Re: MS227 County Comments- Comment Response

The following letter should address all outstanding comments for MS227 in order to clear the way for us to go before the BOCC for formal hearing and approval of the Space Village Subdivision.

SPACE VILLAGE FILING NO. 4  
A PORTION OF THE NW 1/4 OF SEC. 17, T14S,  
R65W, OF THE 6th P.M., EL PASO COUNTY, COLORADO  
GRADING & EROSION CONTROL PLAN

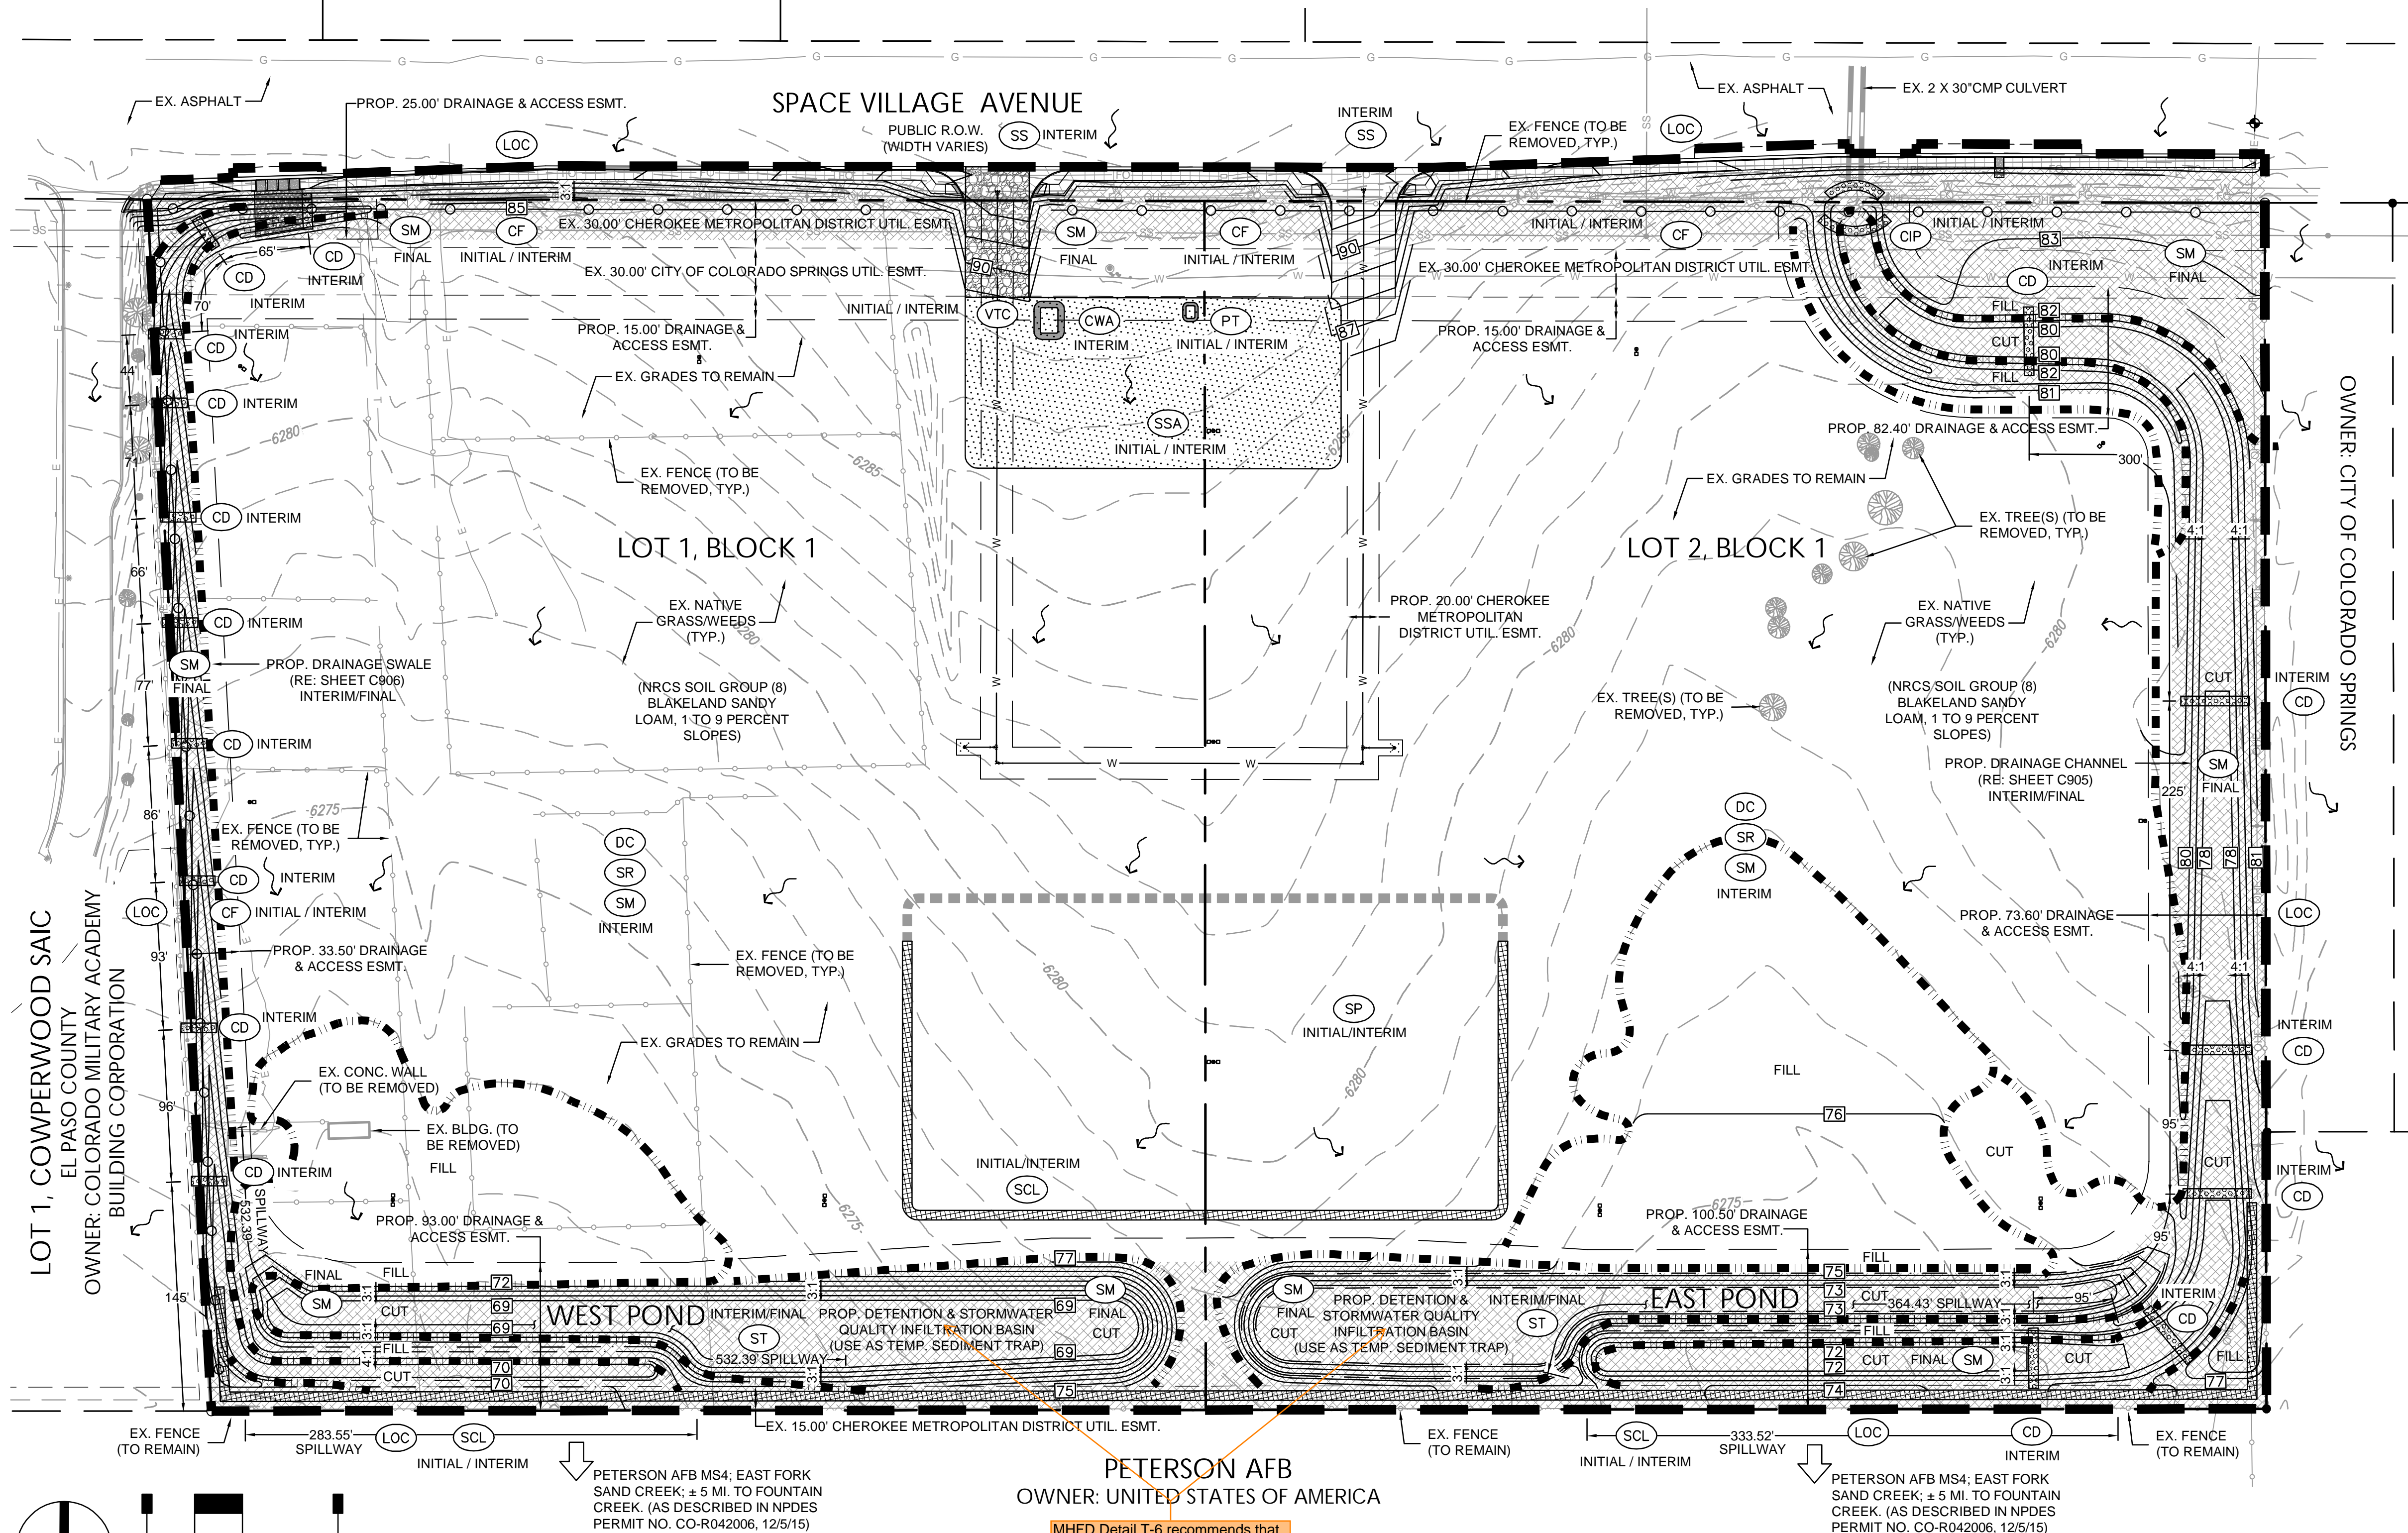
- *PCD Project Manager final plat minor comment* 12/14/2023  
-The plat with this submittal has addressed the comment related to the Geological Hazard notes
- *Colorado Springs Public Works* 12/18/2023  
-At the north-west corner along Space Village Ave, dedicate a "Public Improvement Easement", PIE, for the public sidewalk outside the Public ROW Verify the dimensions from the construction plan.

*See uploaded sheet with EDRD comment.*  
-Noted. This easement will be provided to the City as part of the City review process before the Roadway Plans can be approved and access permits pulled.
- *County Attorney - Development Review* 12/28/23

**ROADWAY PLAN**

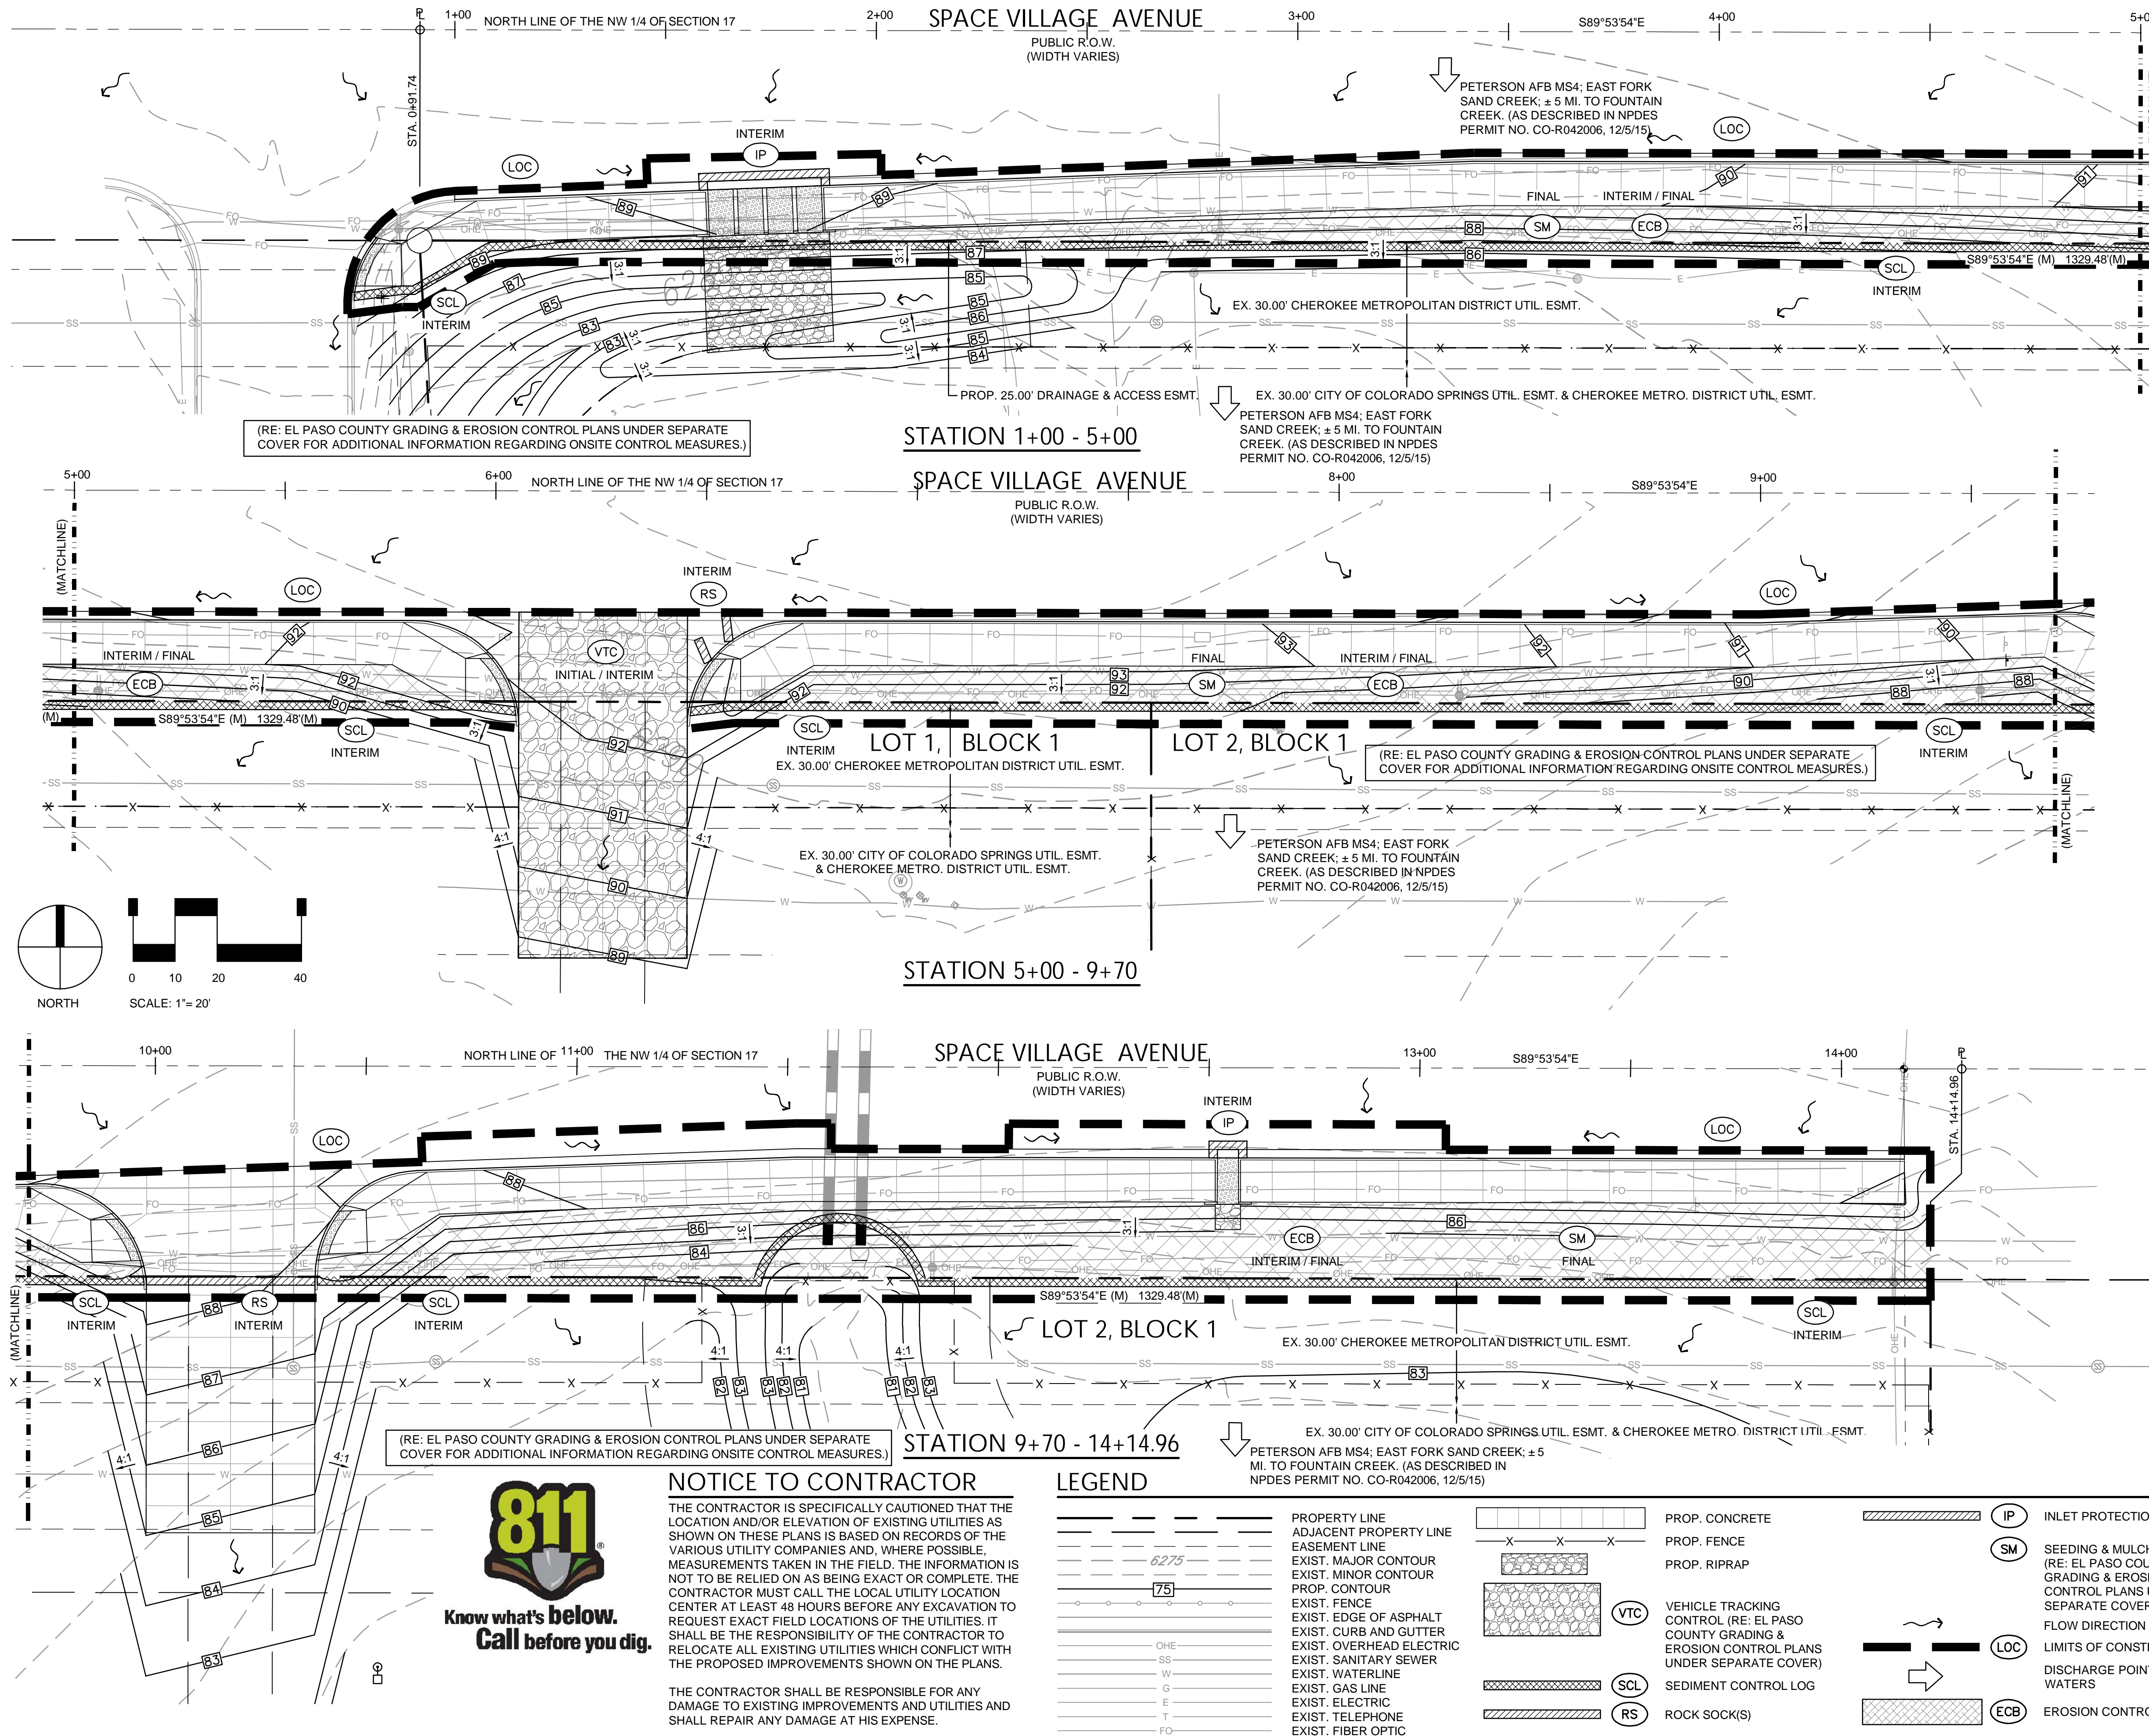
- 1. Please limit the proposed access points along Space Village Ave to a maximum of 36 feet wide.*
- 2- Please align the proposed east site access (Access B in TIS) with 7230 Space Village Ave exiting access.*
- 3- If gates are proposed at any of the access points, then gates will need to be spaces at a minimum of 50 feet from the flow line and provide a turnaround width for U-turn vehicles.*
- 4- Please show and callout "on the future Development Plan" the speed line of sight with the adequate sight distance length (footage) for the proposed access points along Space Village Ave*
- 5- The developer will be responsible to extend the striping for the two-way left-turn lane (center lane) to the site eastern property line.*
- 6- The details of the signing and striping of the future public roadway improvements will be addressed during the construction plans review.*

*-Noted. The above comments are in process with the City of Colorado Springs Public Works department. Access permits to Space Village Ave are required to be pulled from the City of Colorado Springs. This should not affect approval of the subdivision.*
